From: Kari Parsons <kari@elpasoco.com>
Sent: Tuesday, March 2, 2021 3:15 PM
To: Nina Ruiz <NinaRuiz@elpasoco.com>
Subject: RE: Comments on PC items 4 March meeting

SP-19-003 Preliminary Plan - Windermere

From: Tim Trowbridge <tim.trowbridge@centurylink.net>
Sent: Tuesday, March 2, 2021 12:04 PM
To: Tracey Garcia <TraceyGarcia@elpasoco.com>; Craig Dossey <craigdossey@elpasoco.com>; Mark Gebhart <MarkGebhart@elpasoco.com>; Nina Ruiz <NinaRuiz@elpasoco.com>
Subject: Comments on PC items 4 March meeting

Figure 1

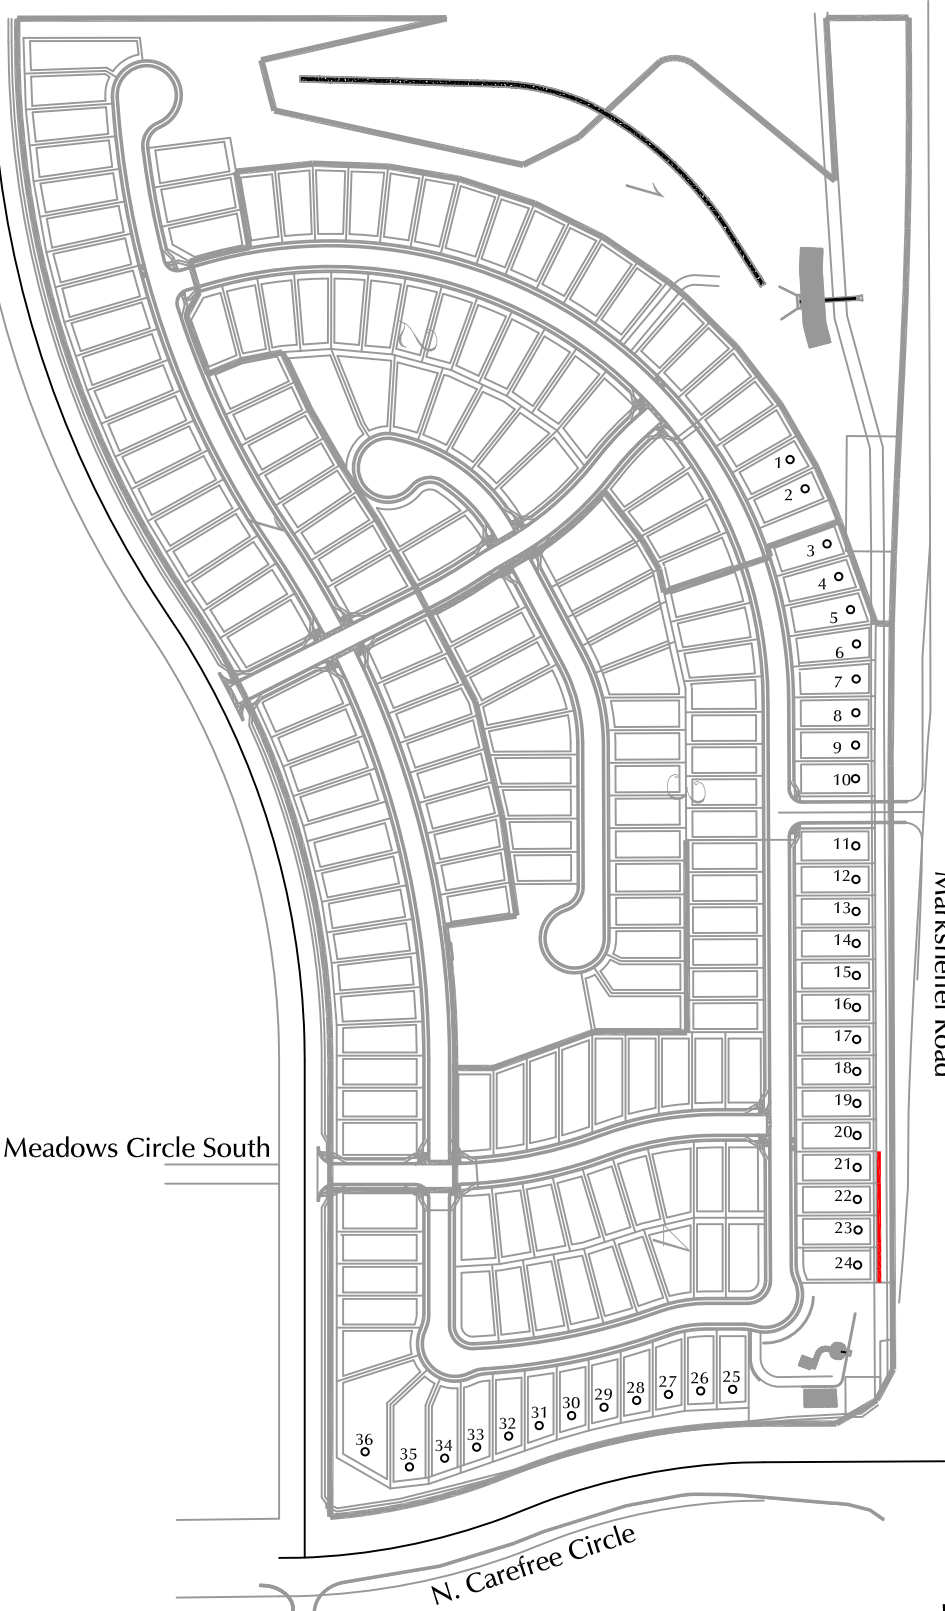
Condition 6: what is the determining factor for 6 vs 8 ft wall?

Is that a result of the updated study? Why not just specify one and be done?

Condition 6: what is the determining factor for 6 vs 8 ft wall? **The Noise study completed by the applicants consultant.**

Recommended Condition No. 6 requires an updated study to determine if a wall is requires along N. Carefree which will identify the height in the areas that need the mitigation at time of final plat. Not all areas require same mitigation (height of wall). With development rising in the area, staff wants to finalize the wall requirements at final plat to help to ensure the future residents have the appropriate noise mitigation.
